Fenwick Solar Project Limited

**Planning Act 2008 – Application for a Development Consent Order for Fenwick Solar Farm**

**Applicant Response to Section 51 Advice Letter dated 29 November 2024**

**Application Ref: EN010152**

PROJECT
Fenwick Solar Farm

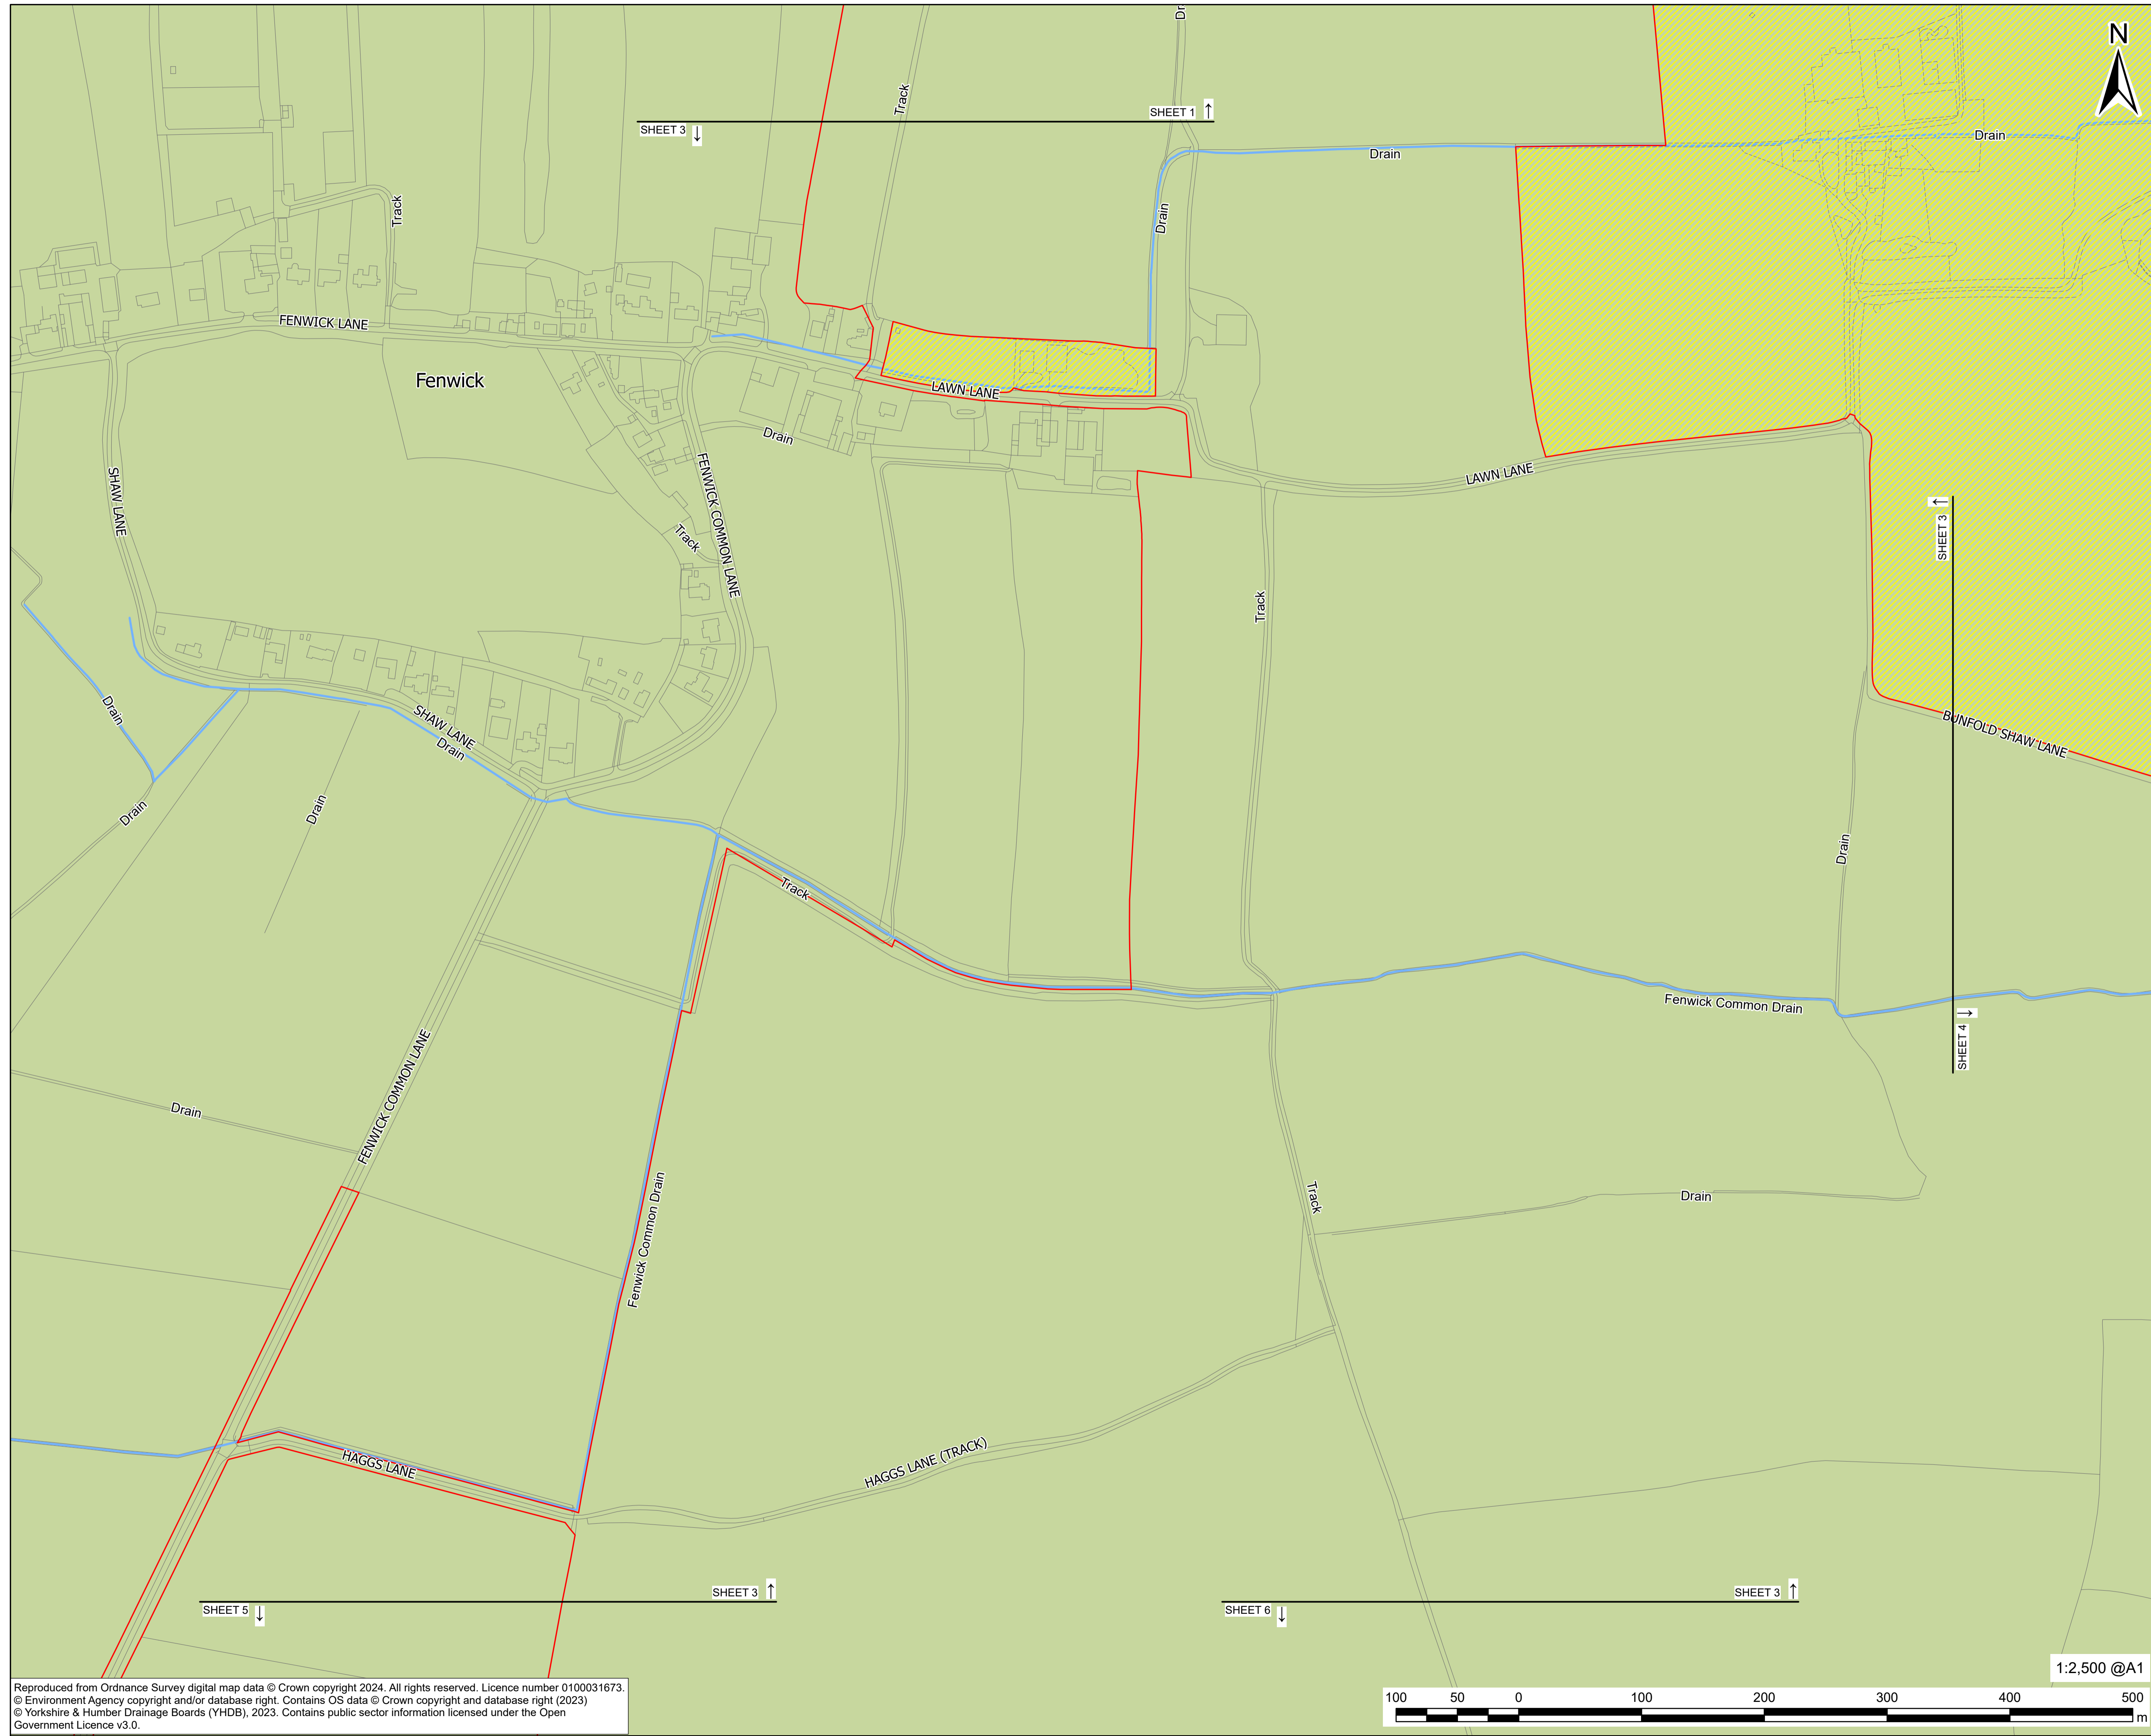
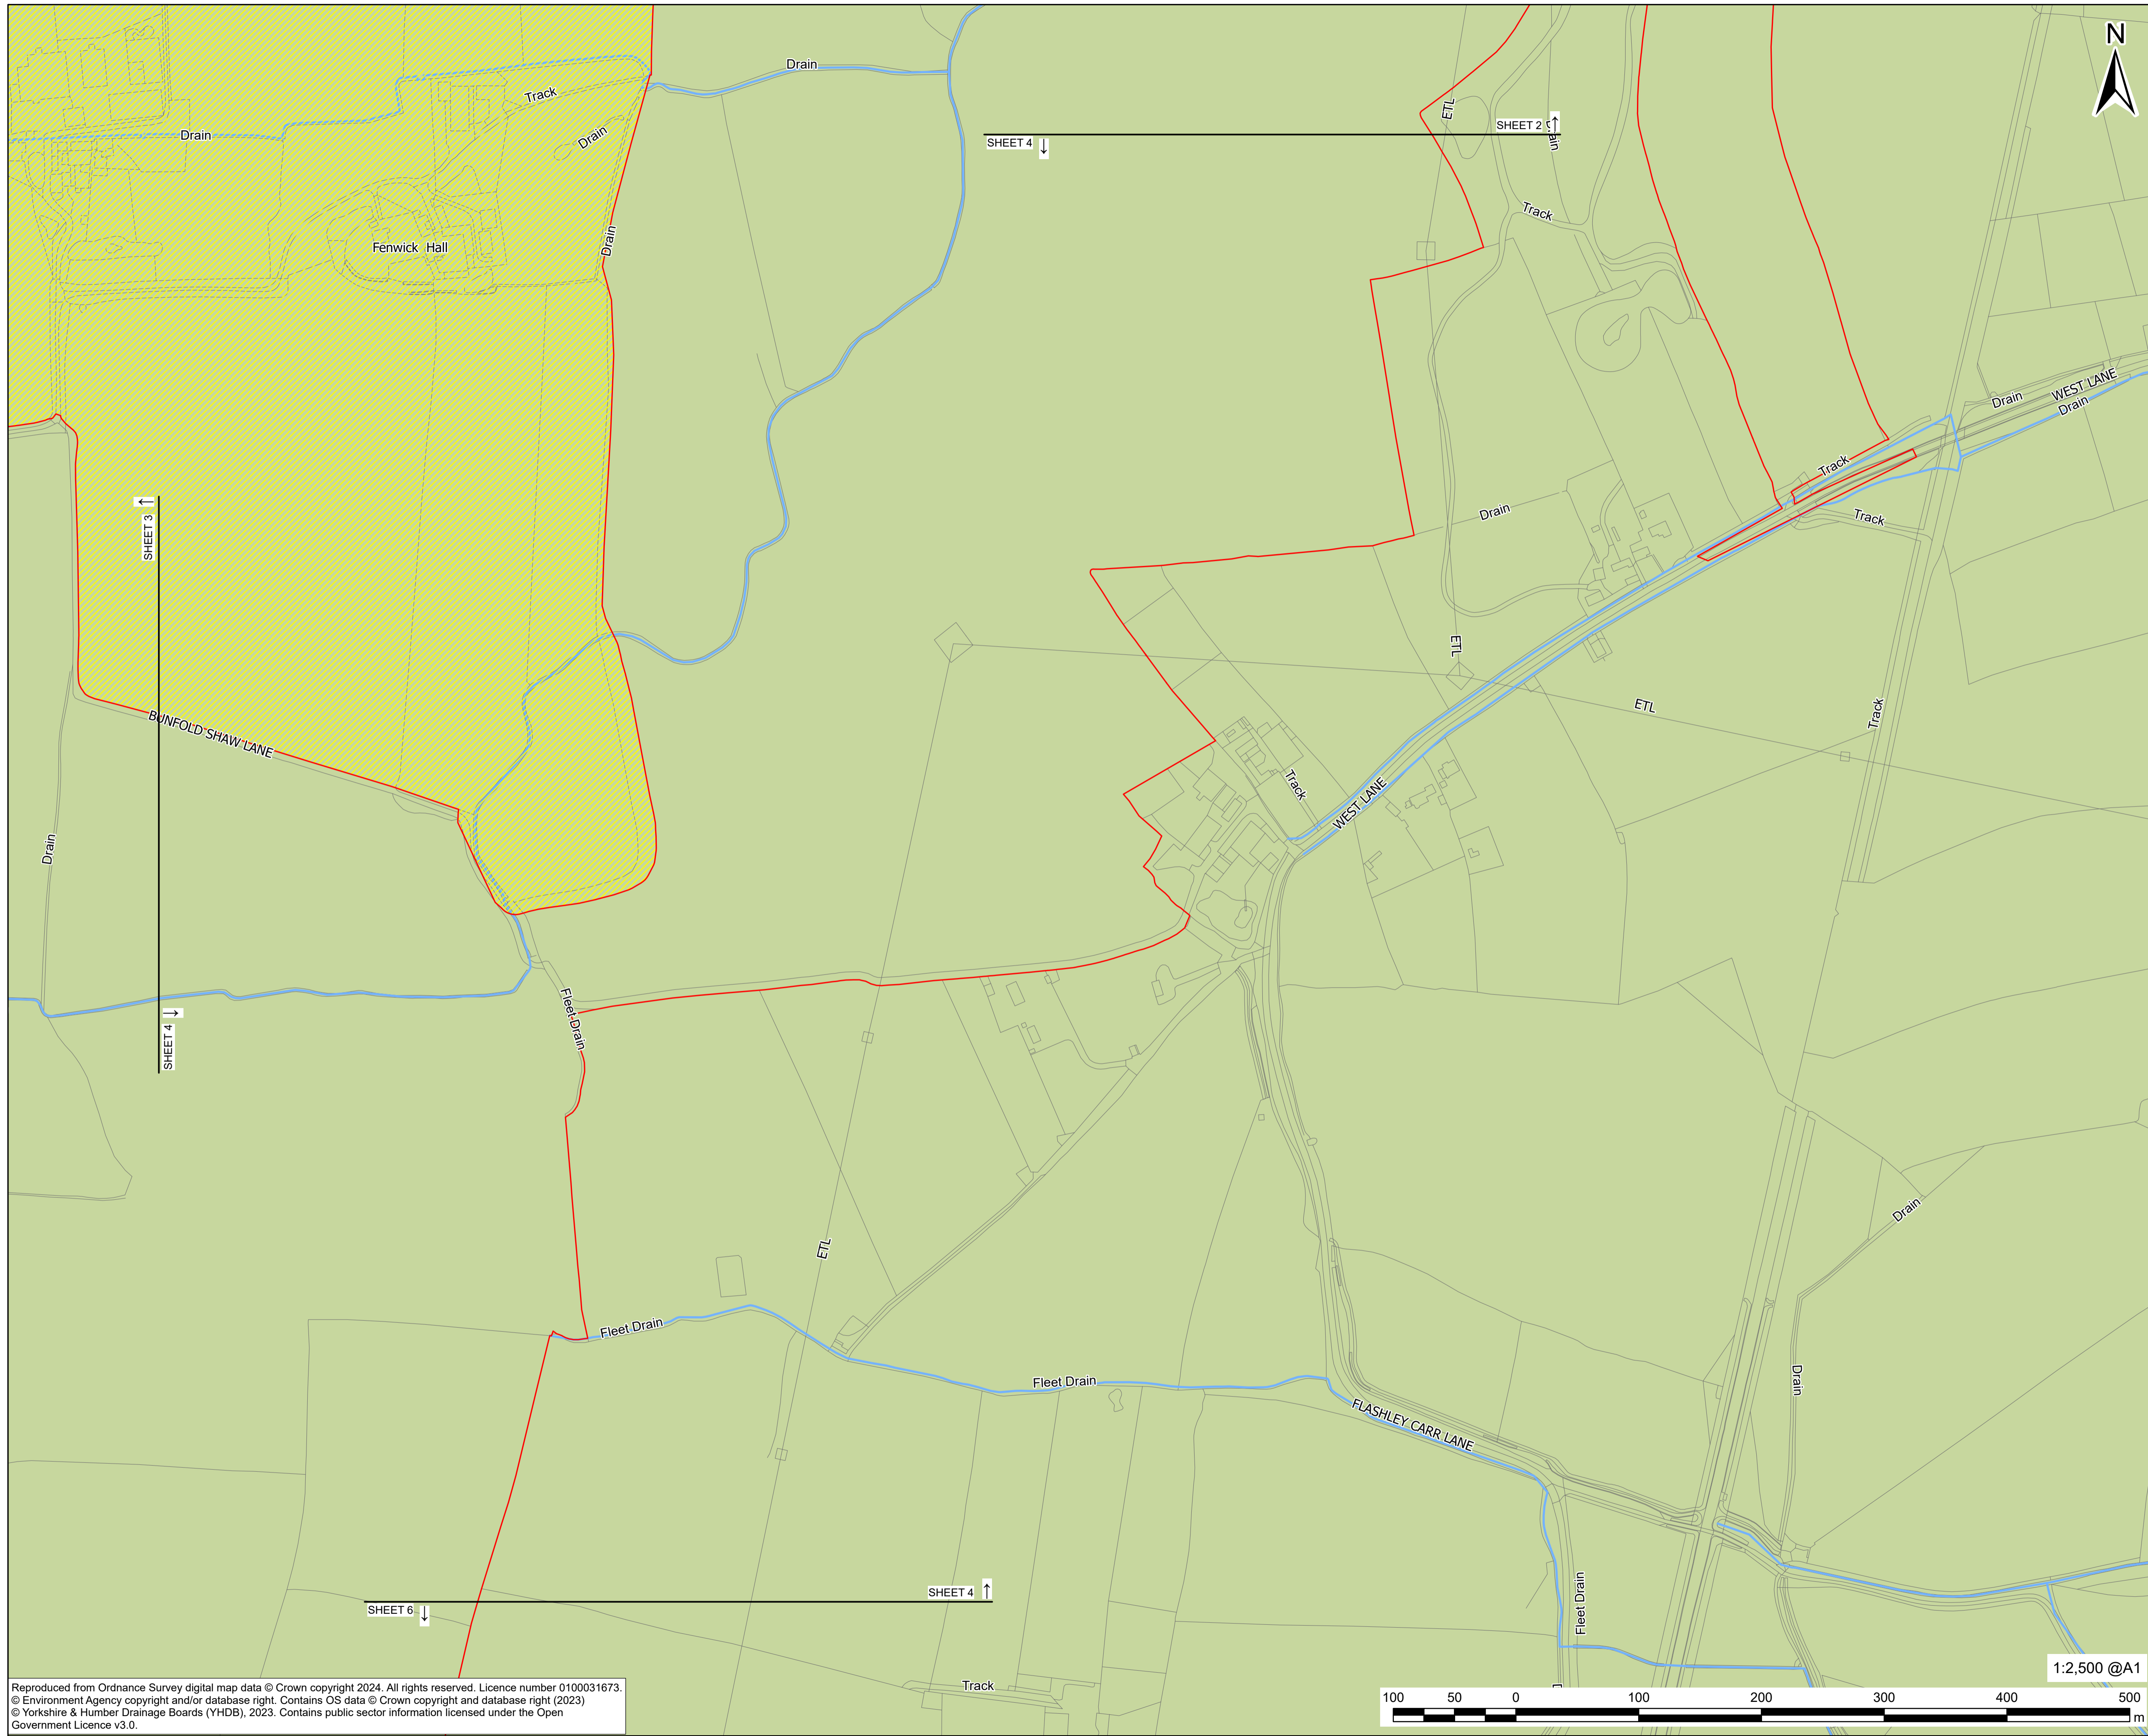
- 1.3.7 The **Waterbodies in River Basin Management Plan [EN010152/APP/2.8]** has been updated by adding missing labels of Ordinary Watercourses that are already identified on ES Fig 9-1 Surface Water Features and Attributes **[EN010152/APP/6.2]**. Also, the updated Plan adopts a lighter blue for Ordinary Watercourses, a darker blue for Main River and the colour of the Aire & Don Sherwood Sandstone layer has been changed from green to orange (noting that orange and blue provides a more accessible palette combination).
